Engineers Comments Regarding Surface Water Drainage

Application Reference:	LU/185/25/DOC	Reviewer Reference:	ADC/EXT2/D2134/83
Planning Officer:	Silvie Steiningerova	Date of Review:	22/10/2025
Site Name:	Land West of Holly Drive Littlehampton		
Application Description:	Approval of details reserved by condition imposed under LU/47/11/ relating to condition 10-surface water drainage (see LU/184/25/DOC for approval of details reserved by condition imposed under LU/47/11/ relating to conditions 21-Ecological Management Plan, 22-Construction Method Statement, 23-details of construction compound and 26-Roads Construction Programme).		
Assessment Number:	1 of 2

Application Reference: LU/185/25/DOC Site Name: Land West of Holly Drive Littlehampton	Initial Issue Date: 22.10.2025 Issue Date: 22.10.2025 Reviewer Reference: ADC/EXT2/D2134/83
---	---

TYPICAL MANHOLE DETAILS - TYPE B WITH SUMP (CATCHPIT)

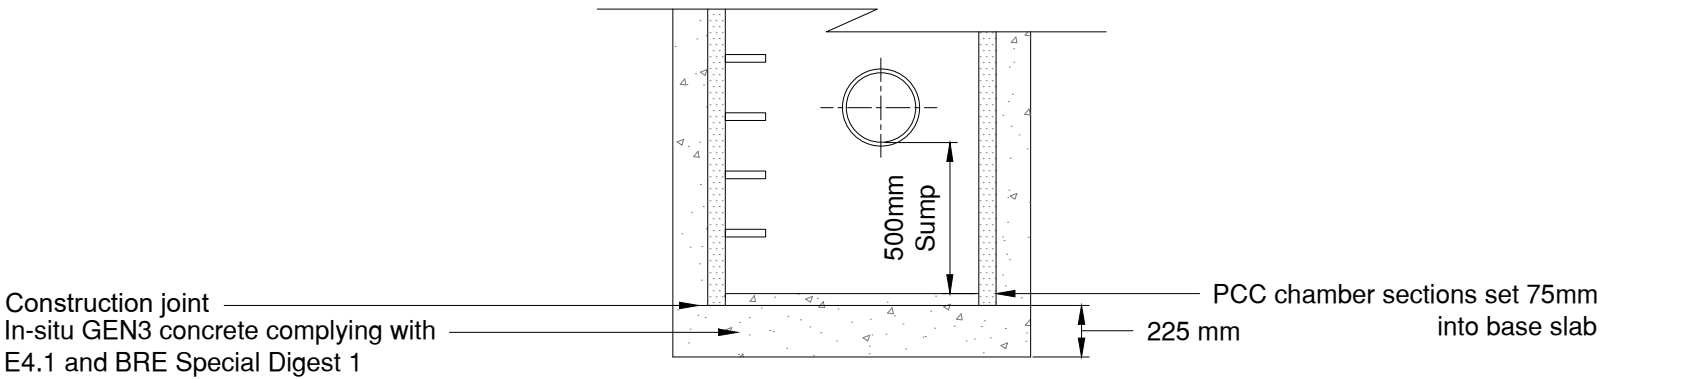
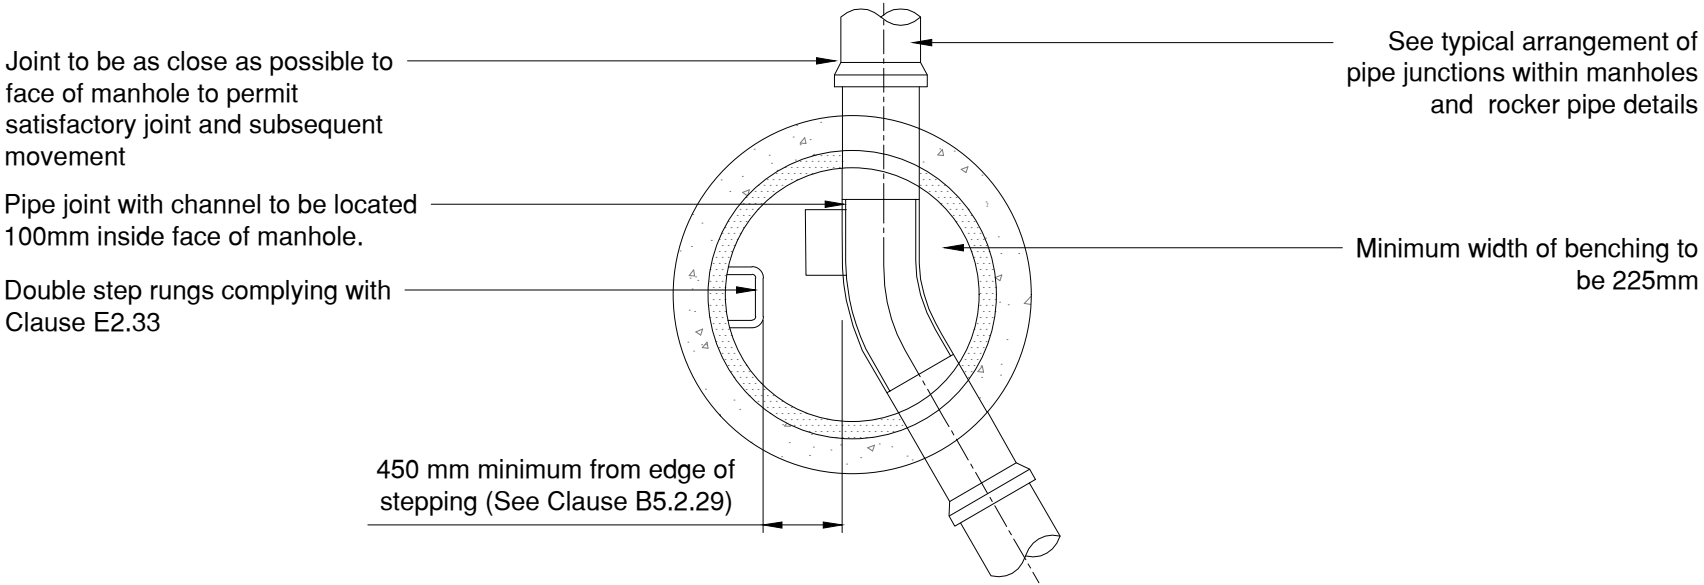
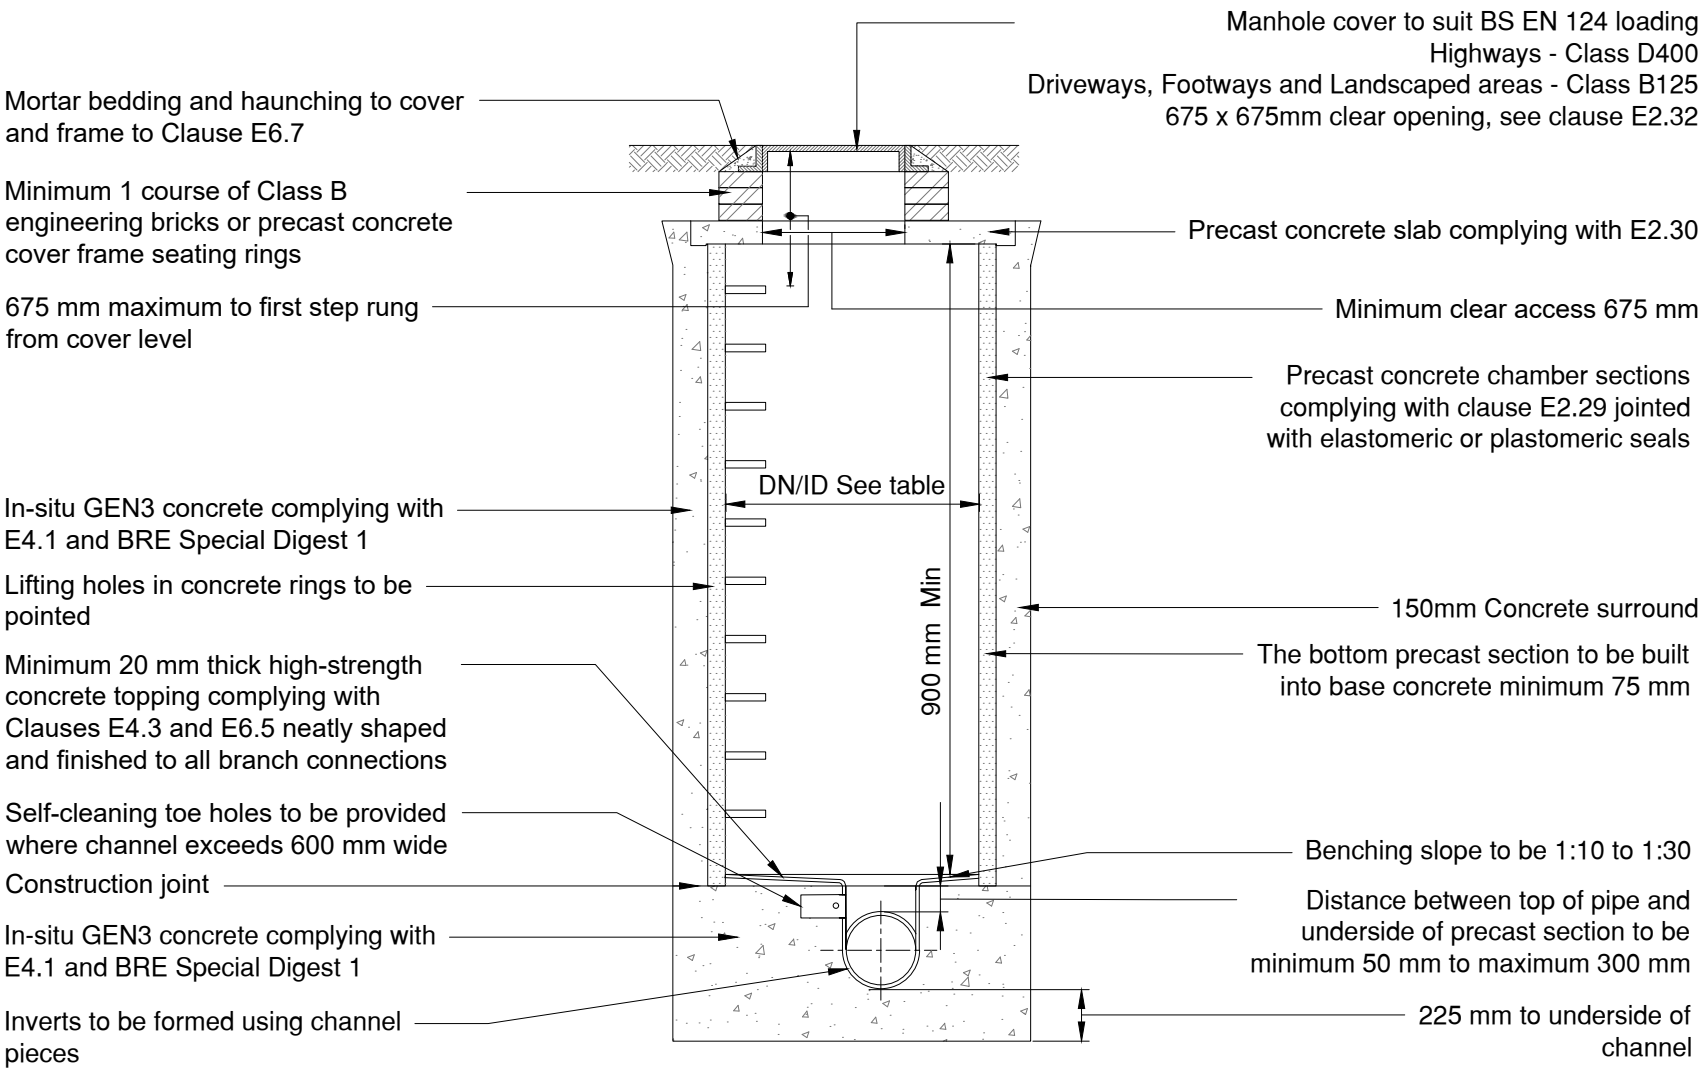
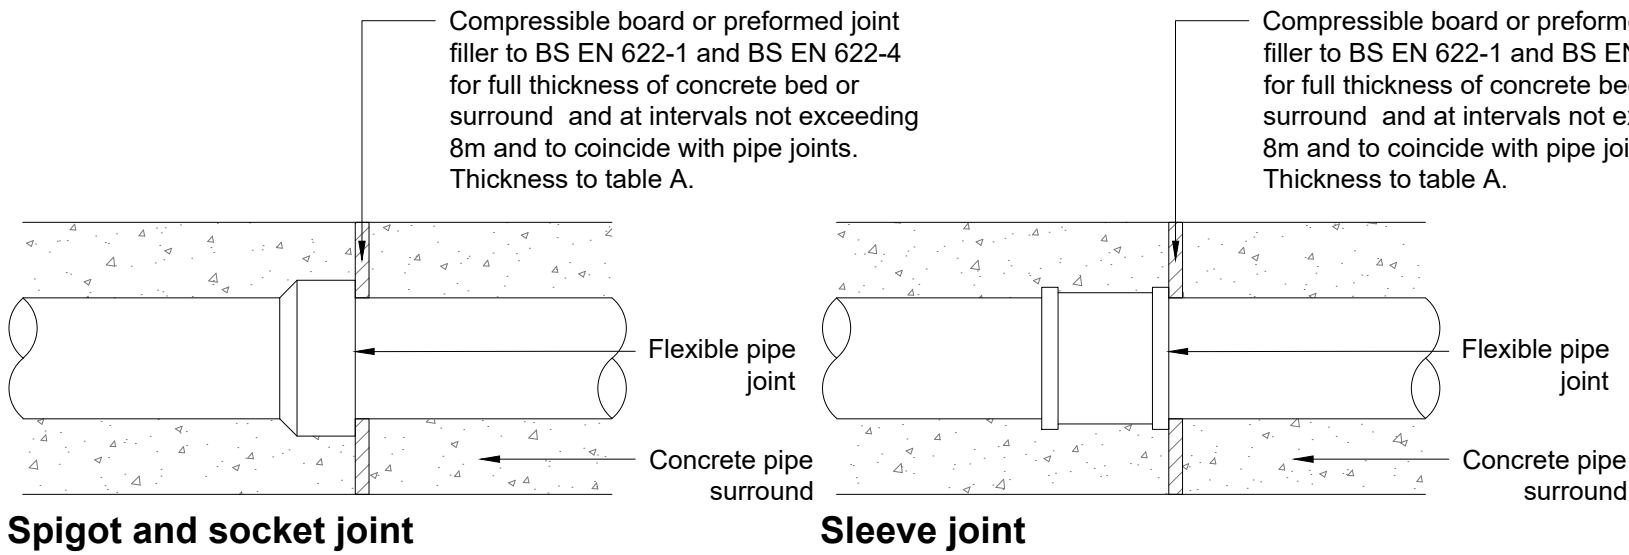
This shall be illustrated for 10yr, 30yr, 100yr. Please note that current standards minimum compliance is required for at least the 30 yr + CC (40%) storm. However, as the scale and layout of the site was agreed prior to this guidance being published we will honour the previous minimum requirement of half drain of the 10yr+CC (45%) storm within 24 hours if necessary.				
12.	Cellular storage criteria does not match drainage plan and details sheet 2 size. This must also correlate with the supplier product being specified.				
13.	Construction details sheet 1 shows a type B manhole which is not used, please remove any details not relevant to the scheme.				
14.	Please include a standard detail for the PCC ring catchpit and qualify the base sump depth.

Cellular Soakaway 1
Coordinates

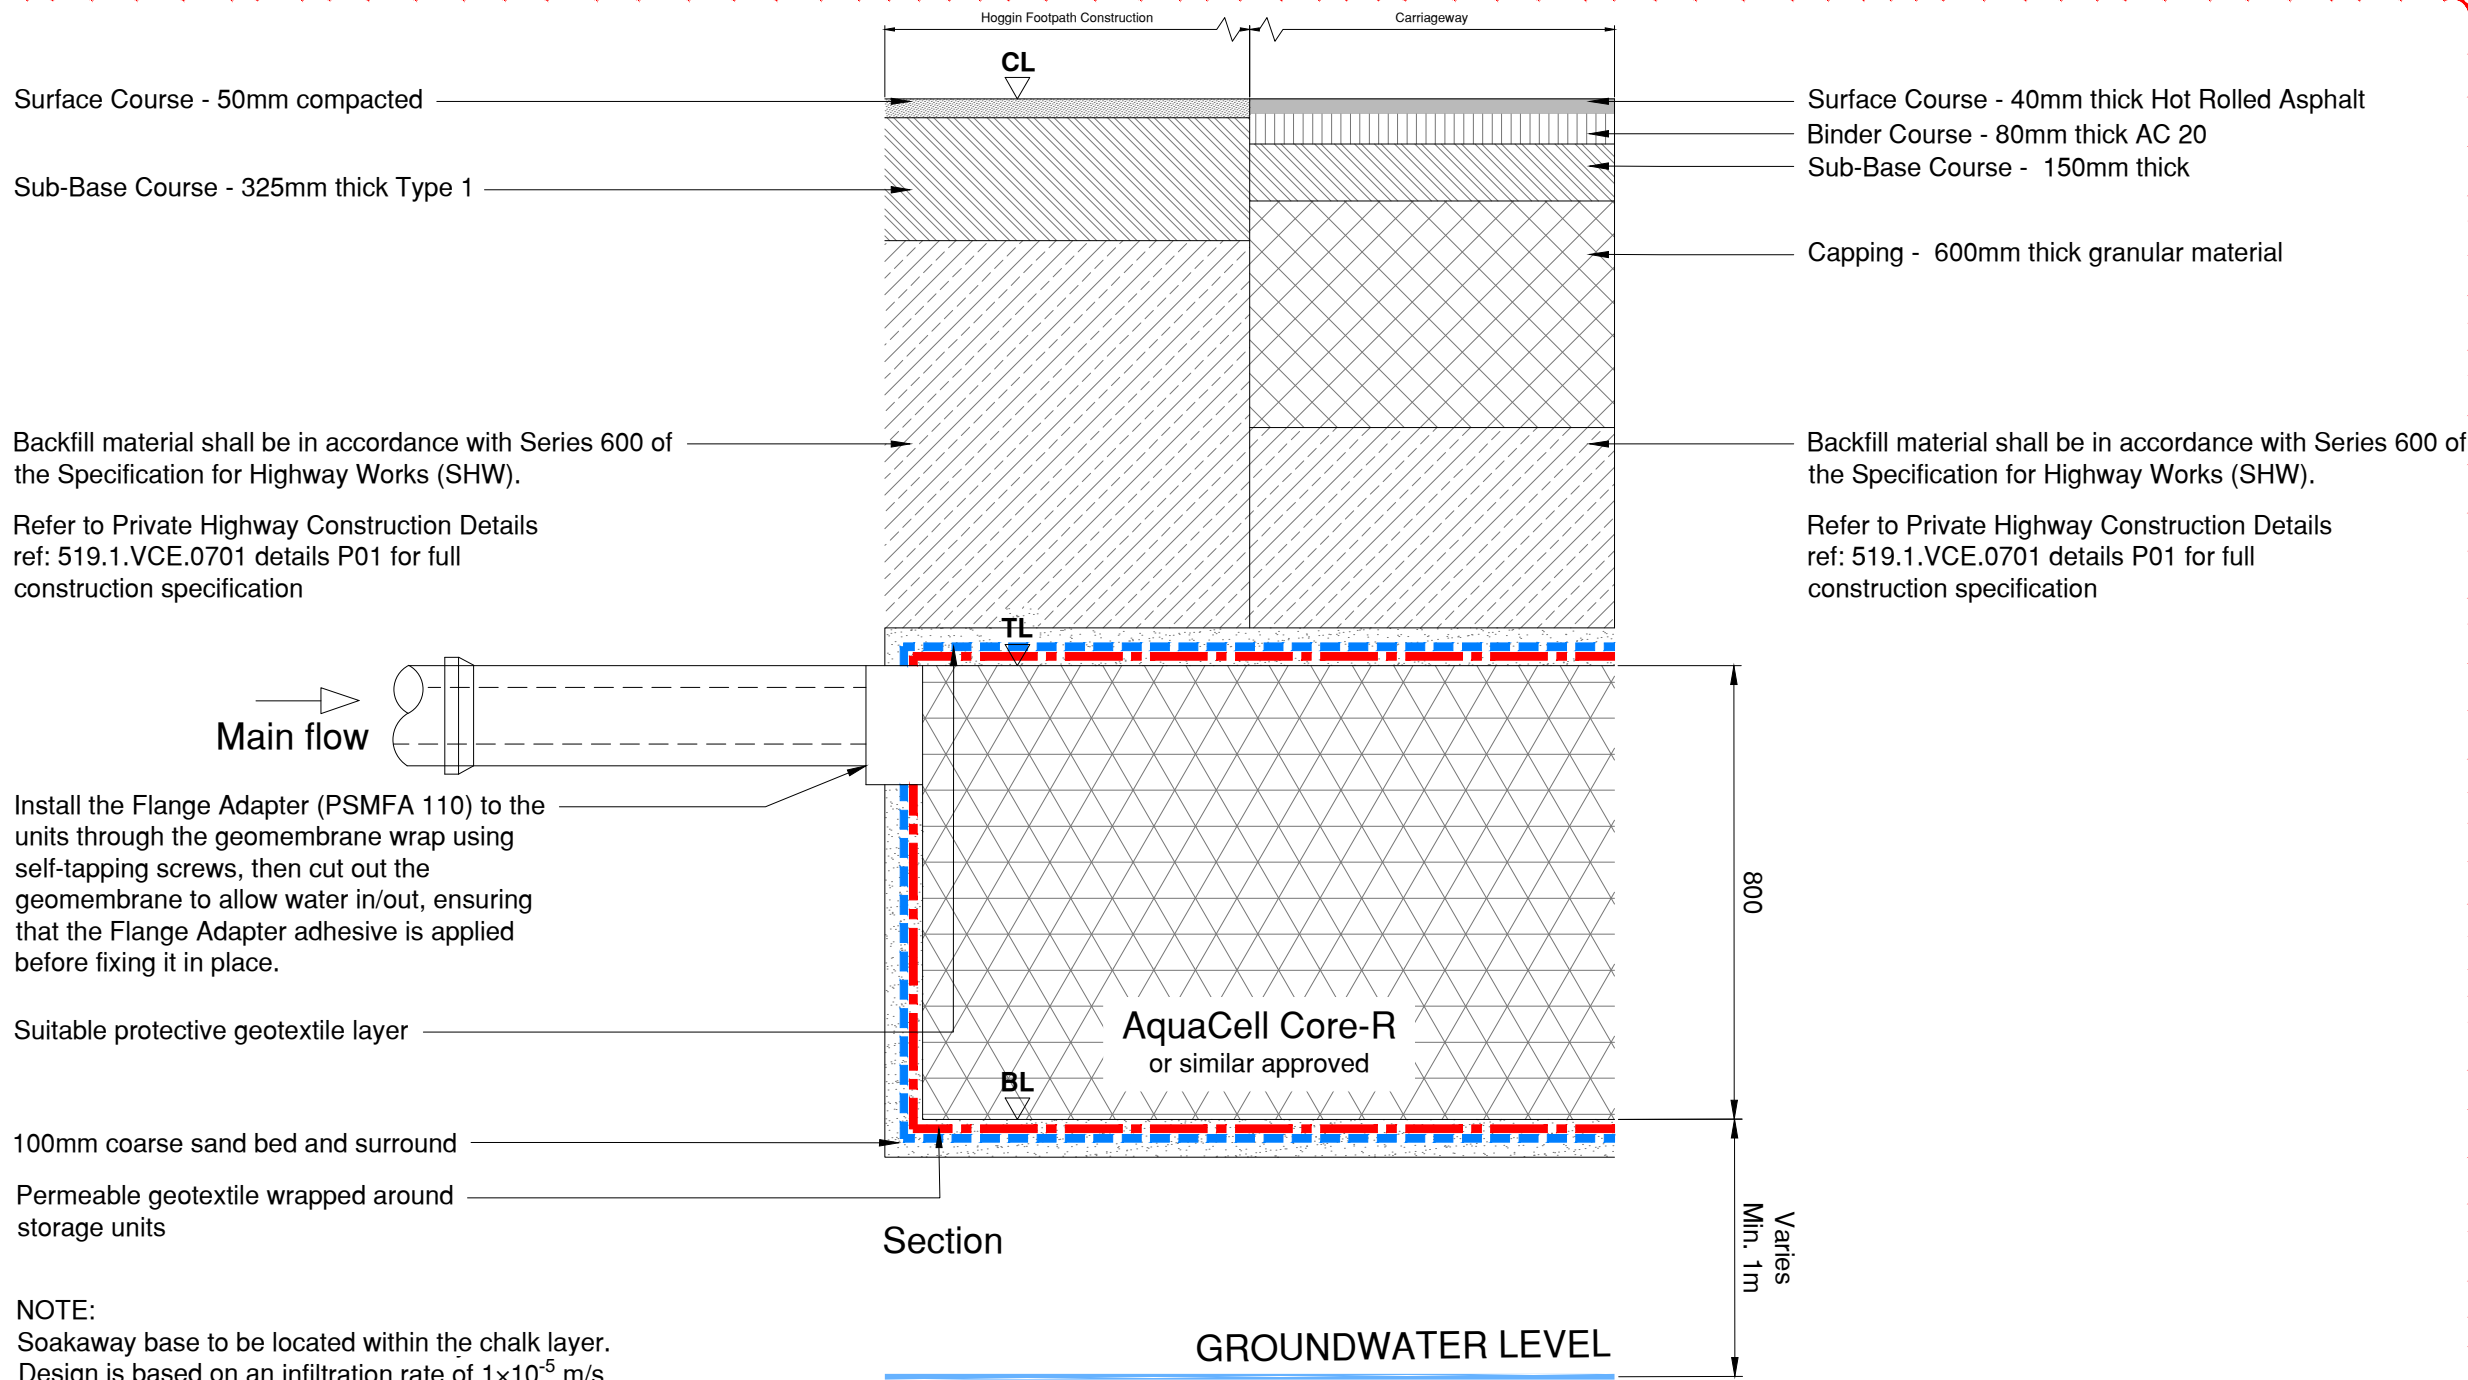
15.	Drawing 511 illustrates the longitudinal sections, however the S1 section does not show the sump or connection to the soakaway.				
16.	Please review if one catchpit is sufficient and qualify CIRIA treatment compliance. What measures will be taken to intercept oils, hydrocarbons etc.				
17.	Please provide a supporting drawing to demonstrate the elevation design, low points, crossfall and exceedance flows.				
18.	Please provide a supporting drawing to identify the catchment area cited in the calculations and relevant gully design/spacing.				
19.	Construction details sheet 1 shows yard gullies with B125 grade covers which may not be suitable at this location.				
20.	Construction details sheet 1 describes the cellular soakaway as a trench which is not accurate.

The backfill material is not accurate and may be insufficient for vehicular loading. Please update and where necessary provide further plan drawings to verify surface finishes (pavements & landscaped areas). The plan advises the soakaway base must penetrate certain layers however this is not qualified on this detail.				
21.	Additional surface collection features may be necessary to mitigate the risk of runoff entering the Public Highway and visa vera.
